Consultation Response from Mike Hibbert,
KC Waste Strategy(Refuse & Recycling)

2024/91316 Clough House, 236, Leeds Road, Birstall, Batley, WF17 0HW

Conversion of existing dwelling and outbuilding to create 6 apartments and erection of 17 dwellings

Responding Ref: WPN 24-011

1 PROPOSED SITE LAYOUT  
1 : 500

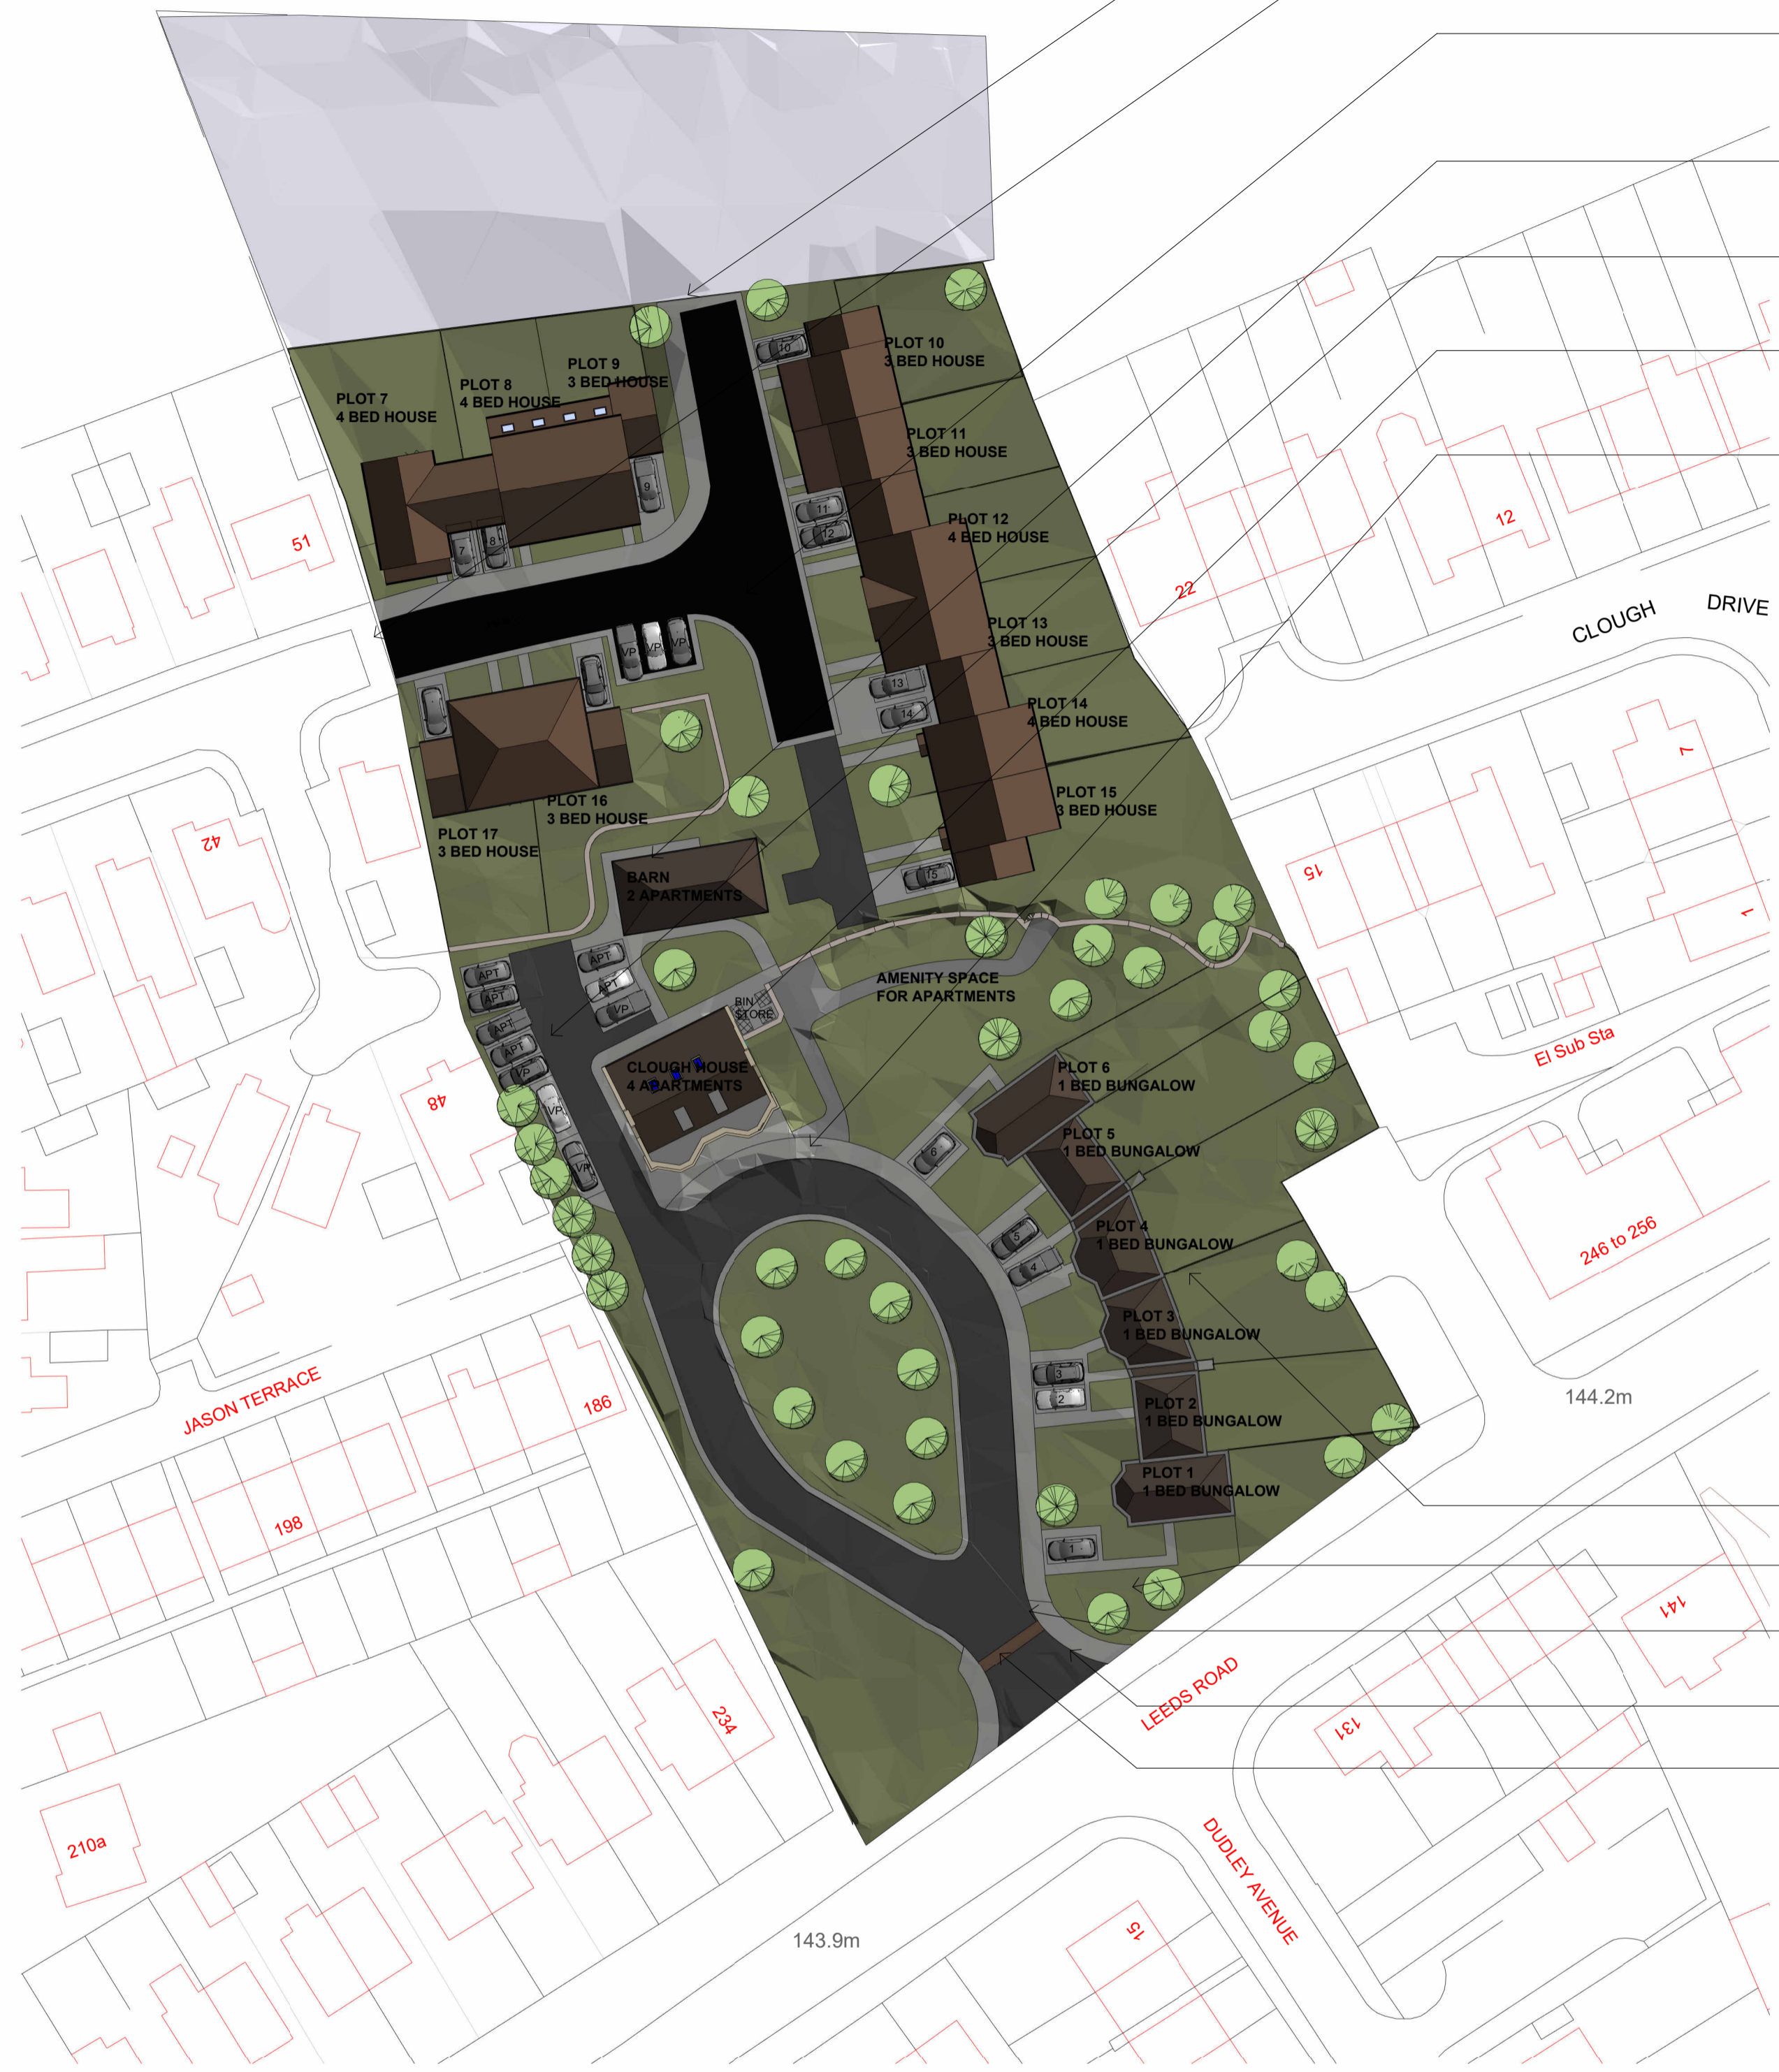
It is stated in the application form that "Bin storage and collection points provided". The applicant has submitted a DESIGN & ACCESS STATEMENT for the ERECTION OF 17 HOUSES AND CONVERSION OF LISTED HOUSE AND OUTBUILDING TO FORM 6 APARTMENTS and a Proposed Site layout & 3D Dwg No (100) 06 Rev A Dated 10/06/2024.

The plan is annotated so show the location of bins stores

Bin Collection Points (BCP's)

- Plots 1-6 do show bin storage to the front of the bungalows. If the residents have restricted mobility and therefore are potentially requiring assisted collections, then

storage to the front is preferable. As these stores will have a visual impact, details/specification of the screening is required.

- The site plan indicates a communal waste storage compound located adjacent to Clough House.

- It is noted that the location of the proposed bin storage facility is adjacent to Clough House and presents a fire risk. Storage should address the fire risk issues presented by large quantities of waste – it must be either 6m away from the building or be constructed of suitable material to contain and prevent the spread of fire. See BS5906:2005, Building Regs 2010 Part H6 and CFPA-E Guideline No 7:2022 F. Relocation of the bin store close to the proposed Bin Collection Point would reduce the potential fire risk and ease collection as bins would not have to be presented by residents on collection day but could be collected direct from the store by the collection crew.

- Waste arisings from 6 apartments will be approximately 1080ltrs. The plan shows provision of a bin store (with dimensions of approximately 4.12m by 3.65m) for four x 660 ltrs wheeliebins that is acceptable storage capacity. The bins shown have dimensions of approximately 129cm x 154cm that follows the dimensions specified in the Kirklees Waste Management Design Guide 2020.

- It is noted that the access road/ extension from Moat Hill Farm Drive into the site includes a turning head in front of Plots 10-13. Active measures should be taken to prevent parking in the turning head as otherwise an RCV would have a long reverse manoeuvre that is a recognised safety risk.

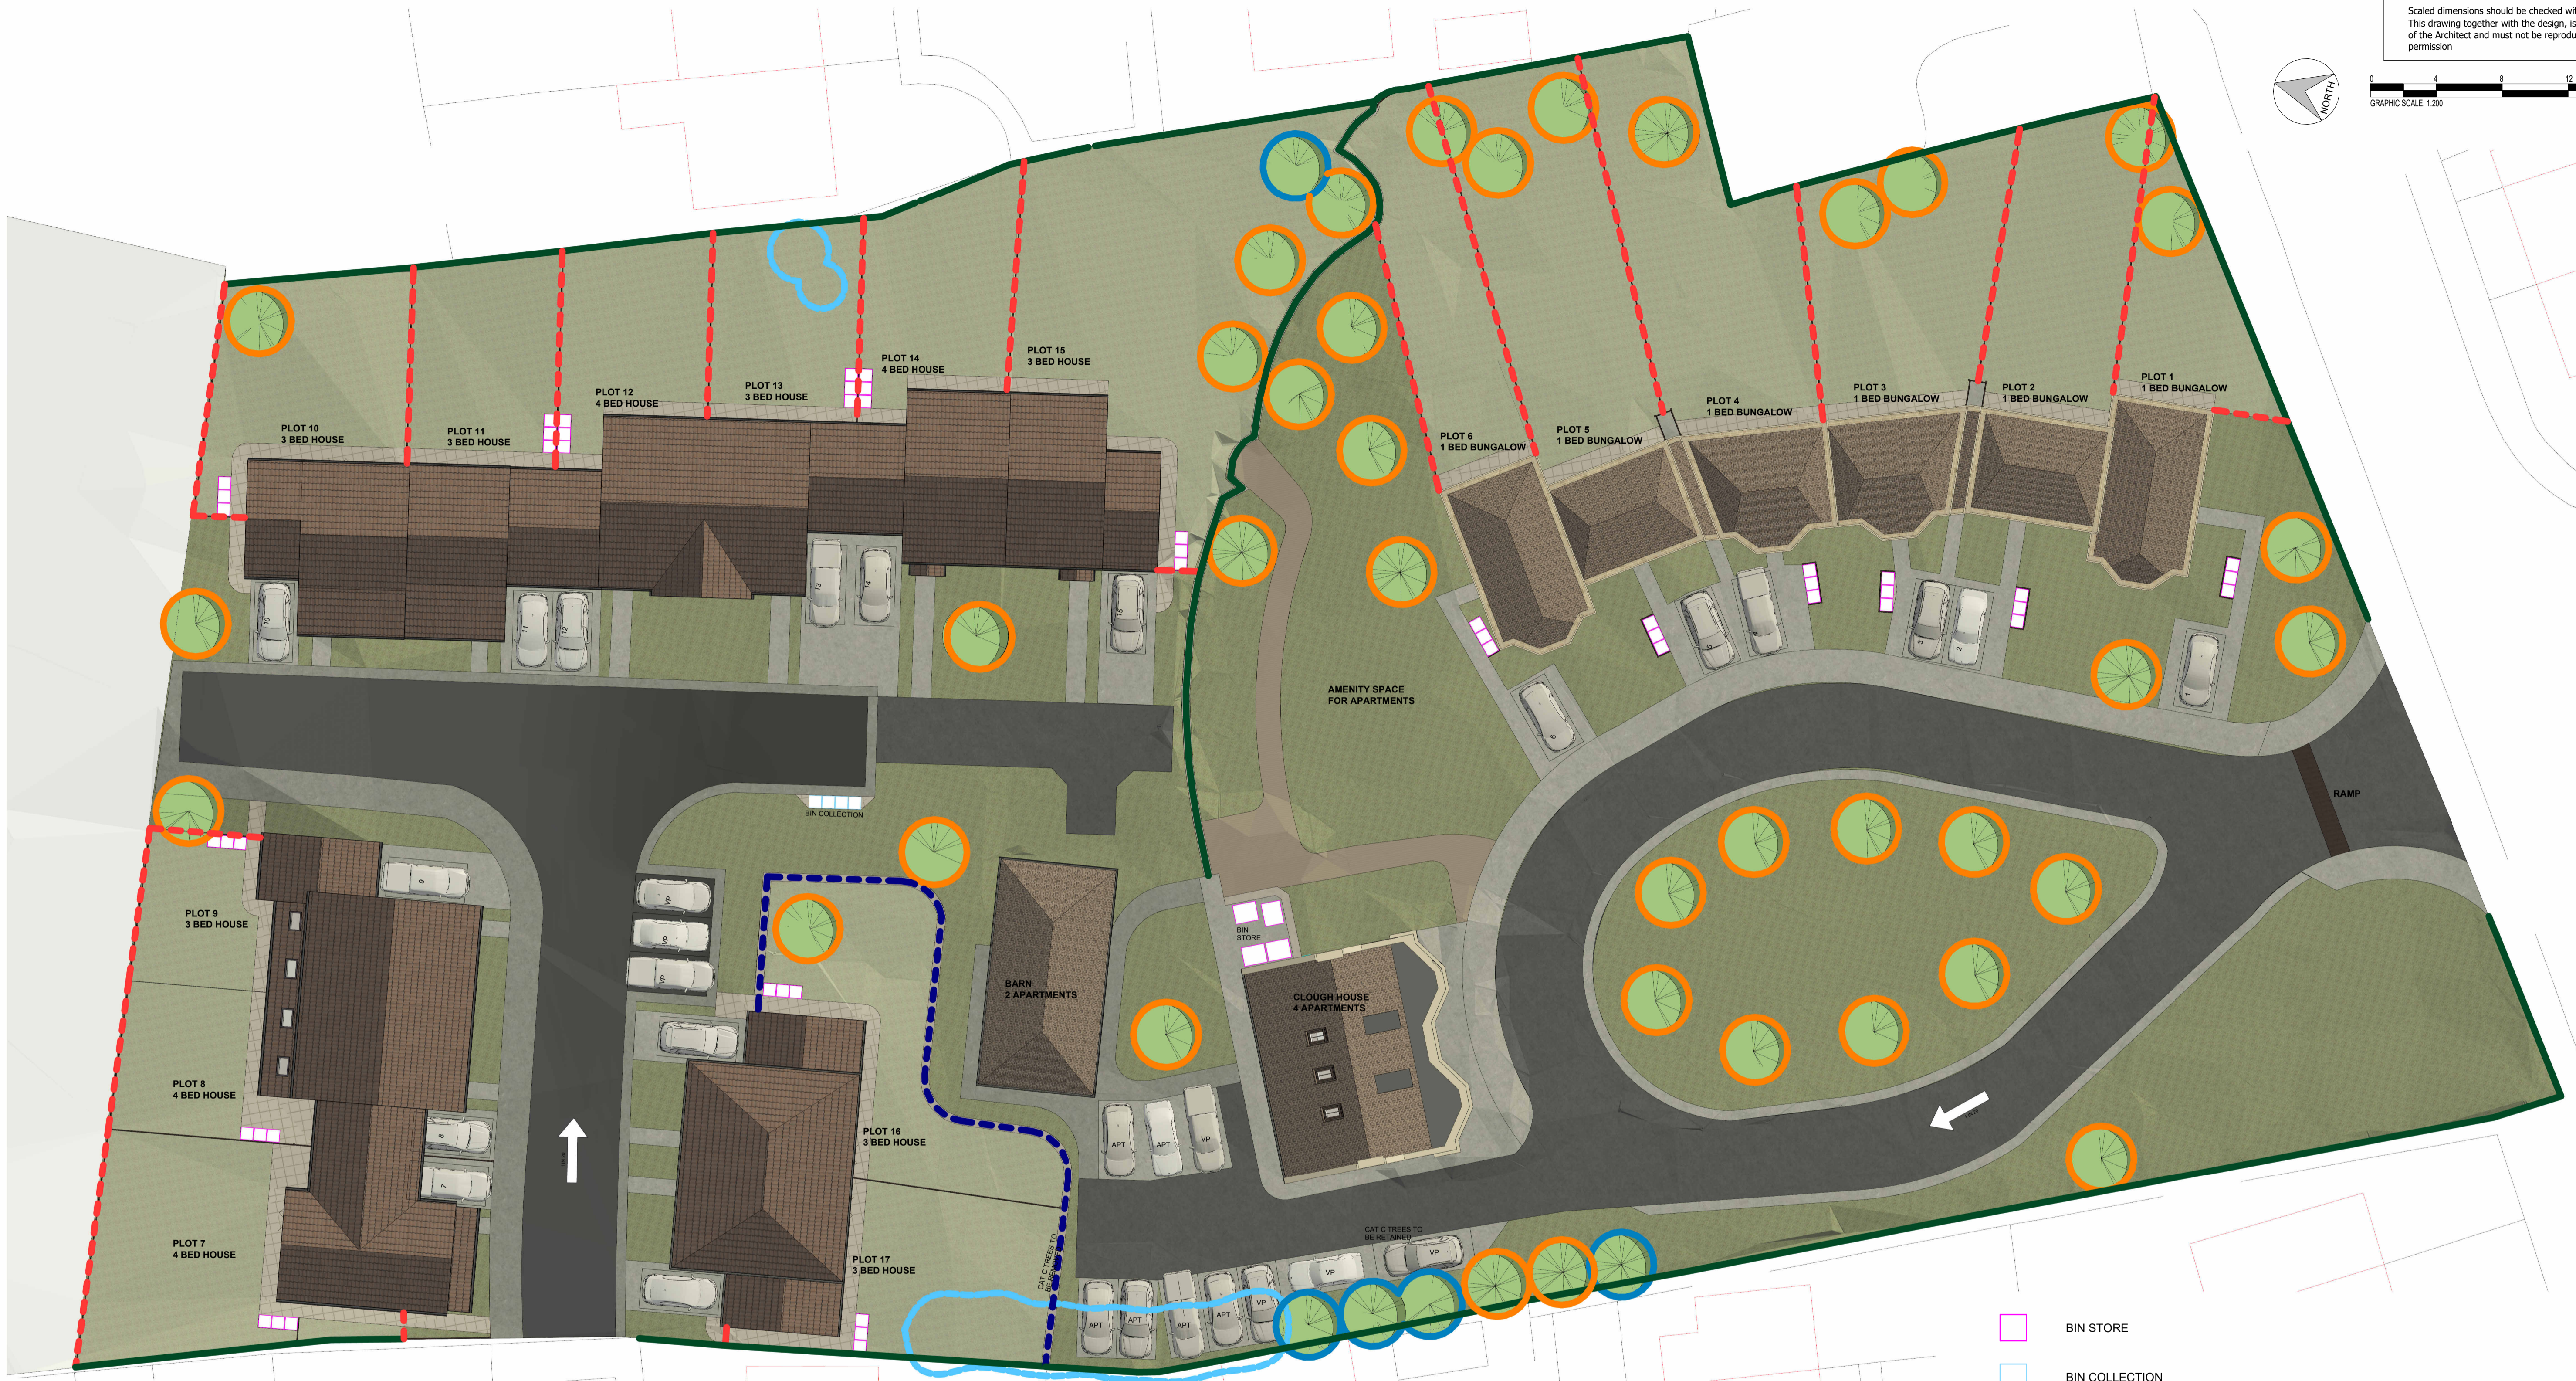
- It is welcomed that is each dwelling (other than the apartments) is shown with space to store 3 x 240ltr wheeled bins (1x residual, 1x recycling and, as the properties have gardens, space to accommodate a garden waste bin) to ensure future waste segregation requirements can be met. As the proposed dwellings have private gardens, opportunities to encourage composting should be sought to better meet the Council's 'clean and green' objectives for waste reduction.

- Bin storage to the rear of properties is preferable but must be easily accessible for residents and not be reached via convoluted routes as this discourages residents from returning bins to the rear, resulting in bin blight in the Streetscene. Access gates and paths from back gardens must be wide enough for bins to pass through. Plots 7 to 17 have rear access via paths or through archways / parking spaces and are acceptable.
